CIVIL

VEHICLE MOVEMENT & TRAFFIC SIGNAGE

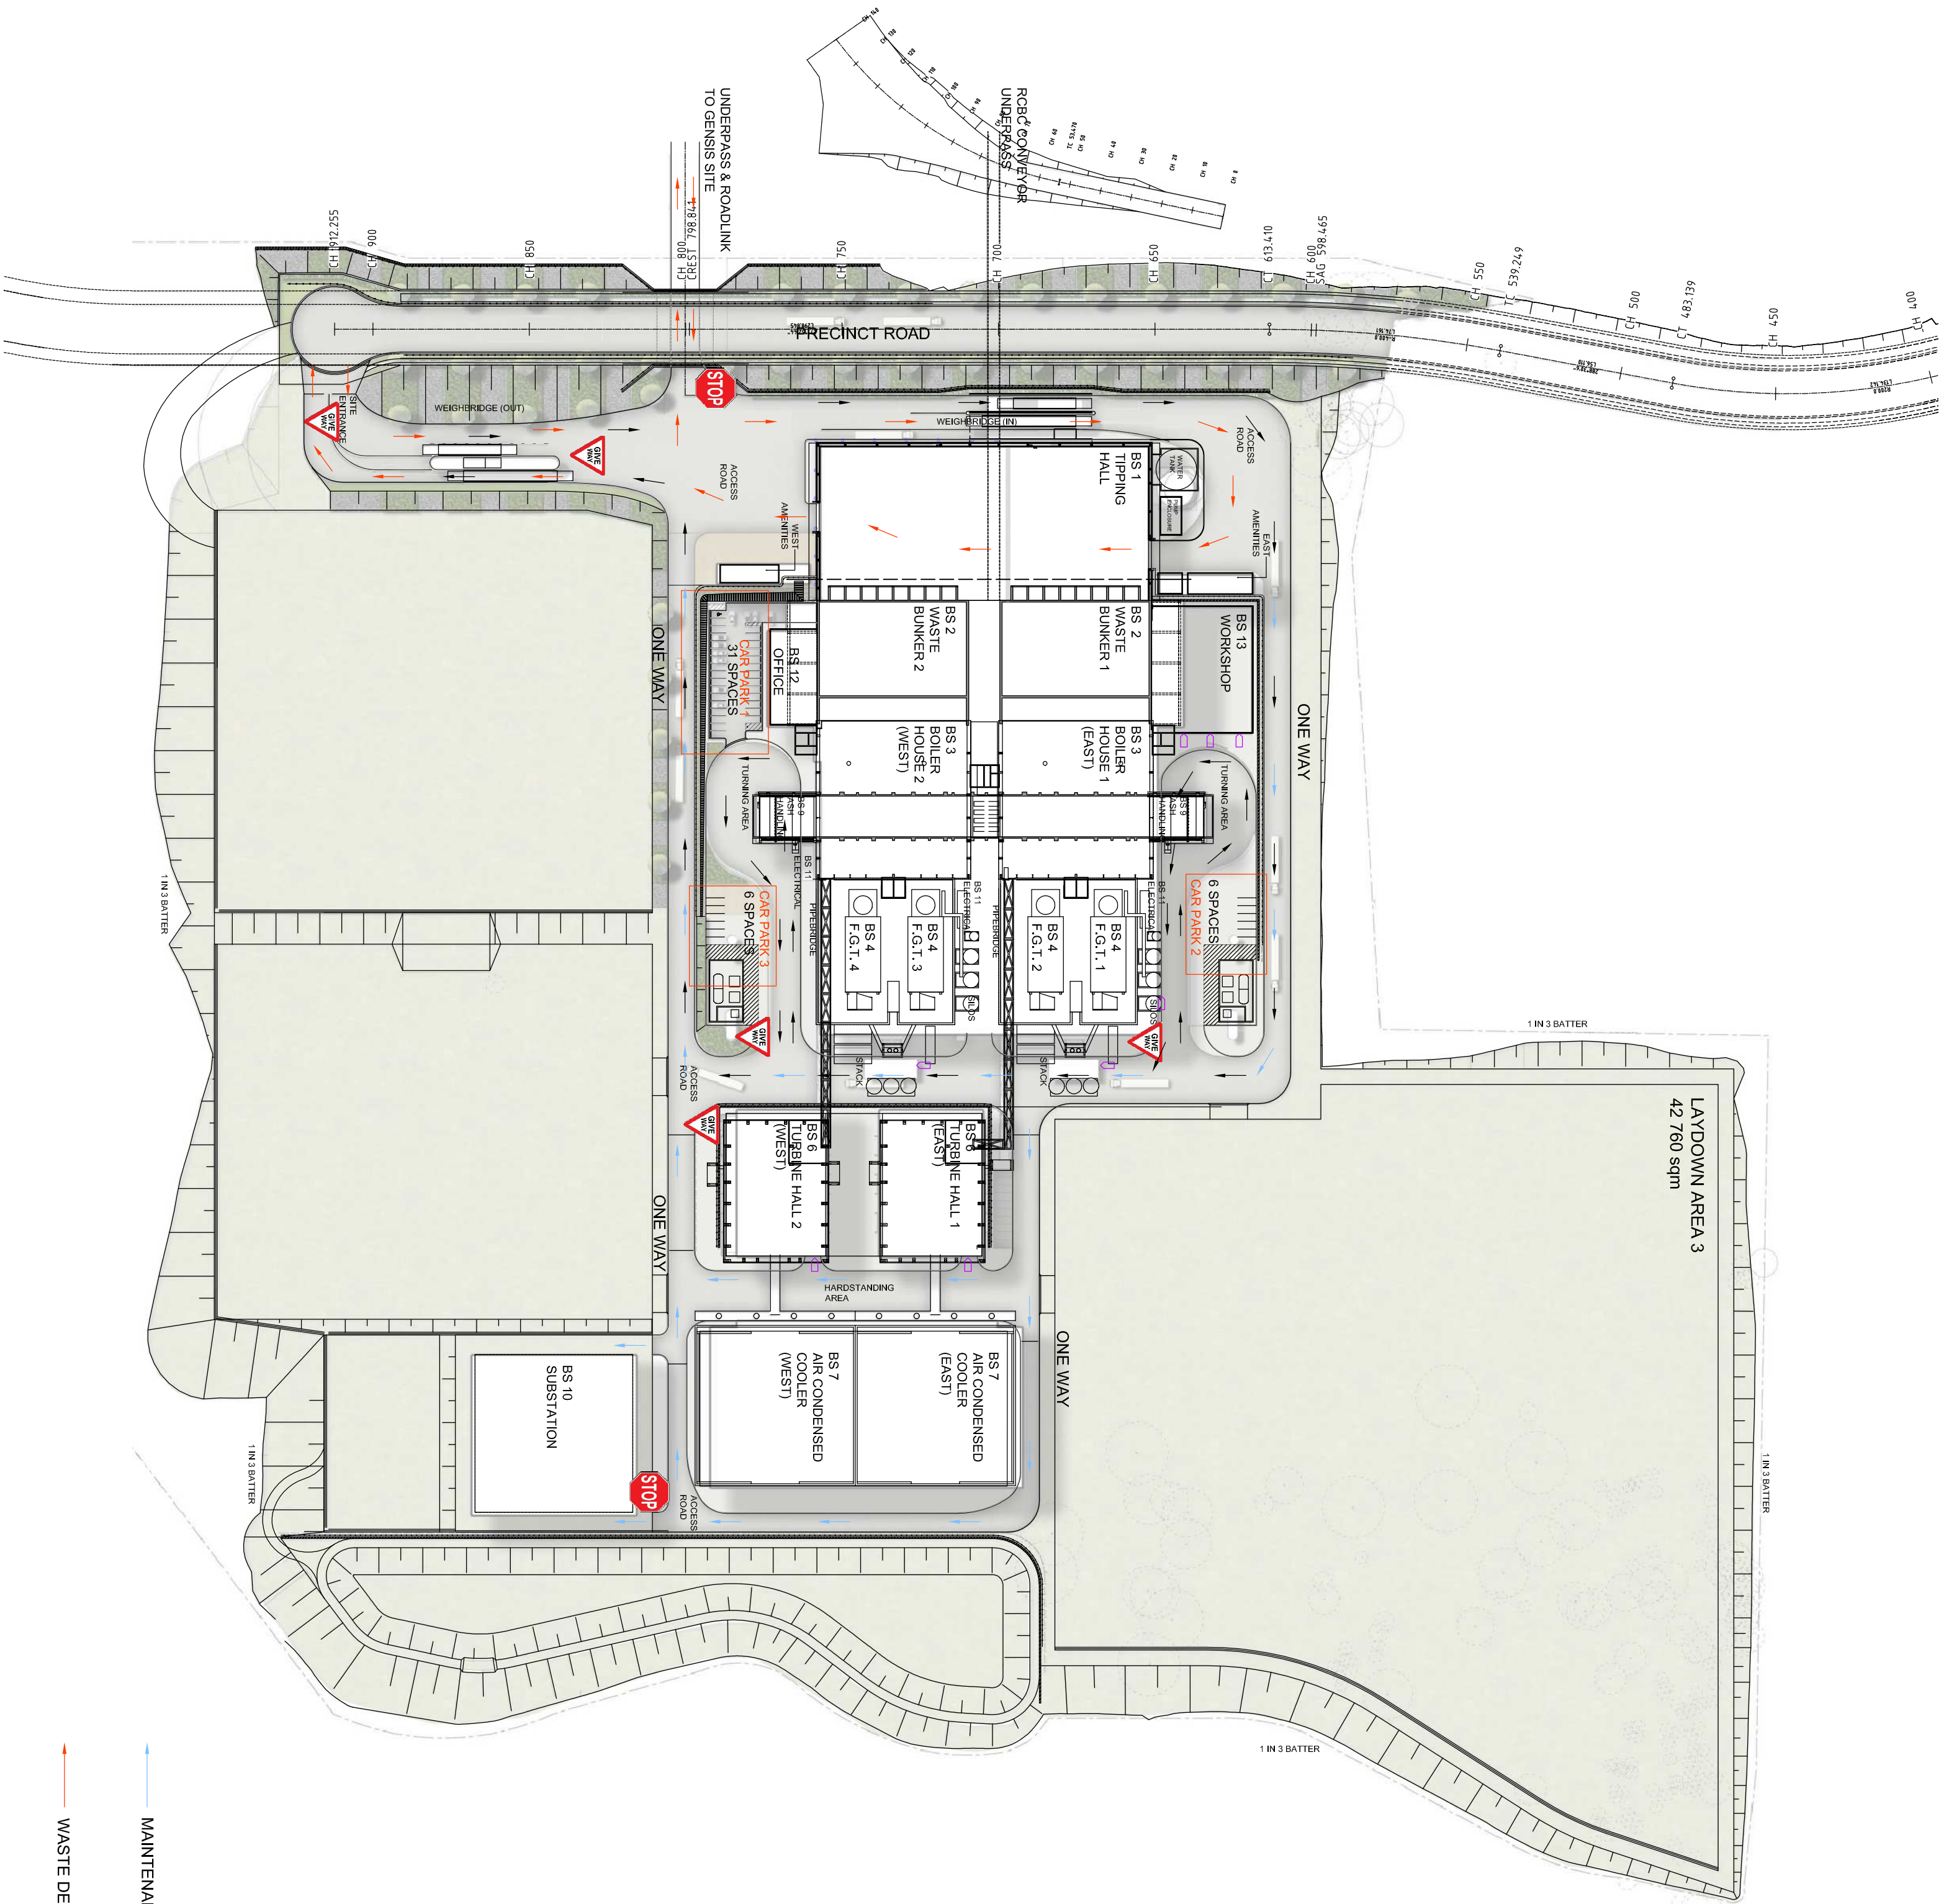
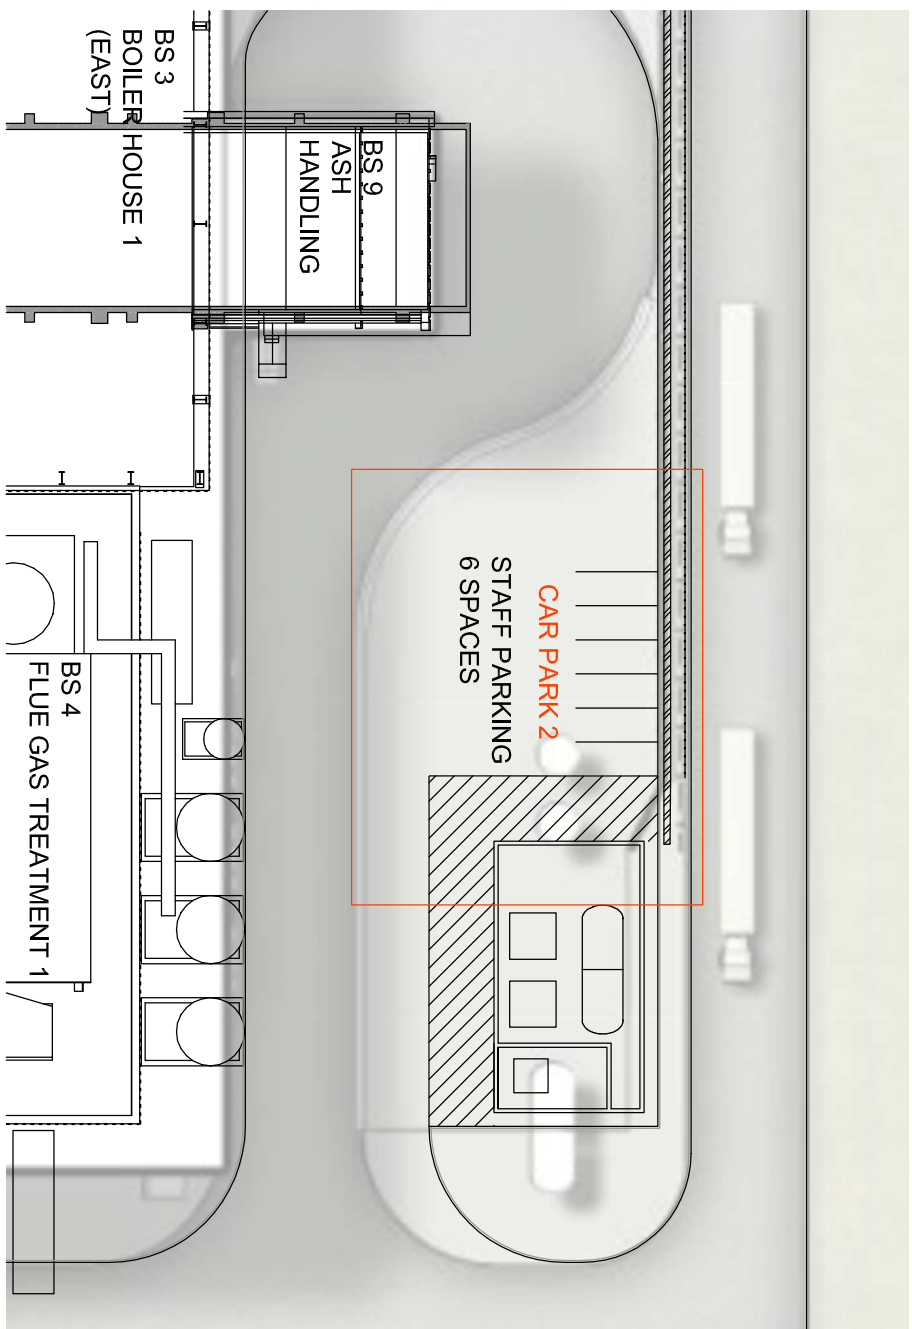
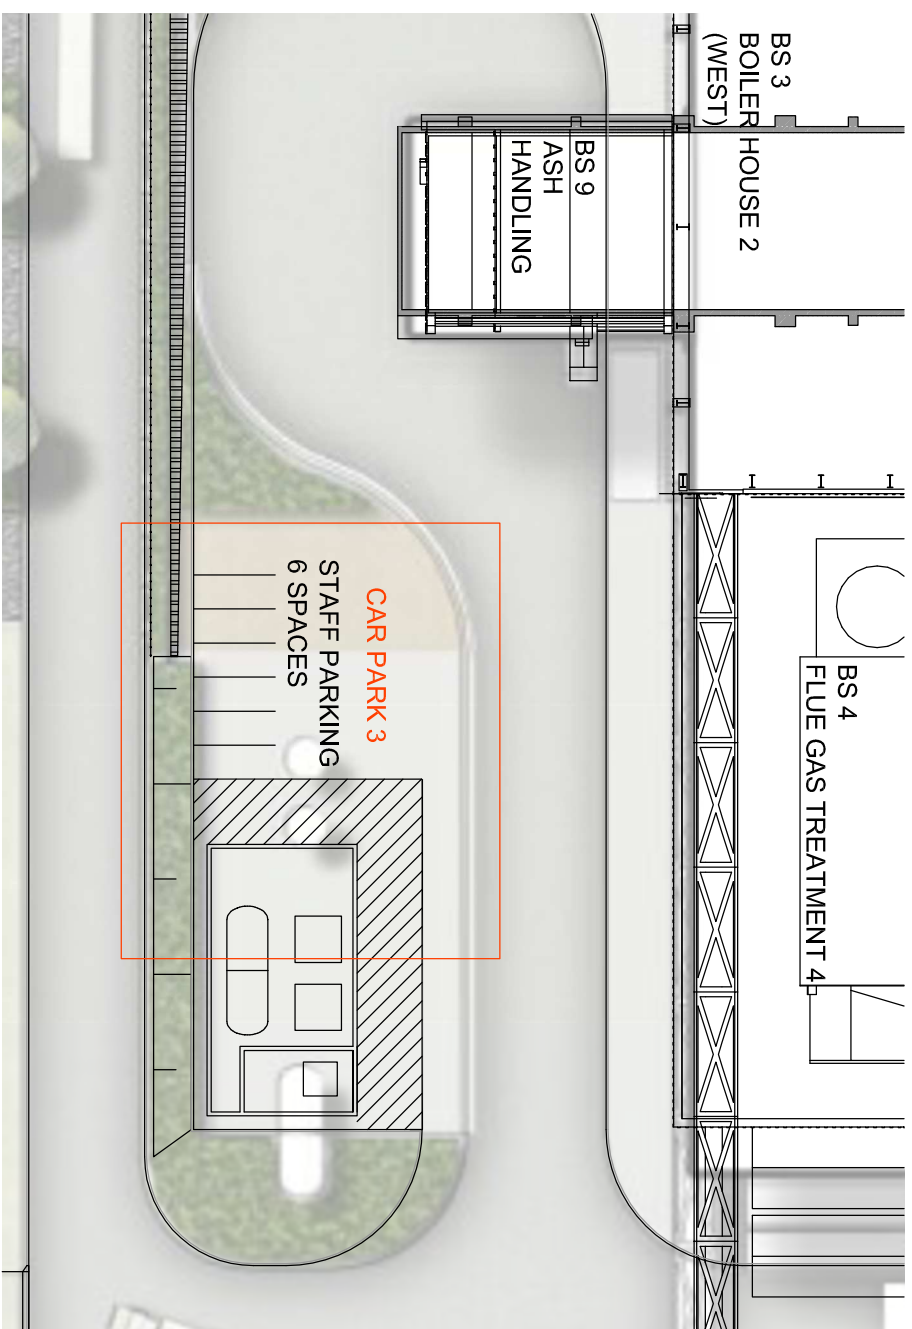
COMMENT	PROPONENT RESPONSE	DOCUMENT REFERENCE
	tributary and the fact that the Australand site is upstream of the Project		
38.	The layout of the proposed car parking areas associated with the subject development (including driveways, grades, turn paths, sight distance requirements in relation to landscaping and/or fencing, aisle widths, aisle lengths, and parking bay dimensions) should be in accordance with AS 2890.1-2004, AS2890.6-2009 and AS2890.2-2002 for heavy vehicles usage	We can confirm the relevant Australian Standards have been used for all road, access and car parking areas within the development.	Refer to the amended Traffic Report at Appendix Q.
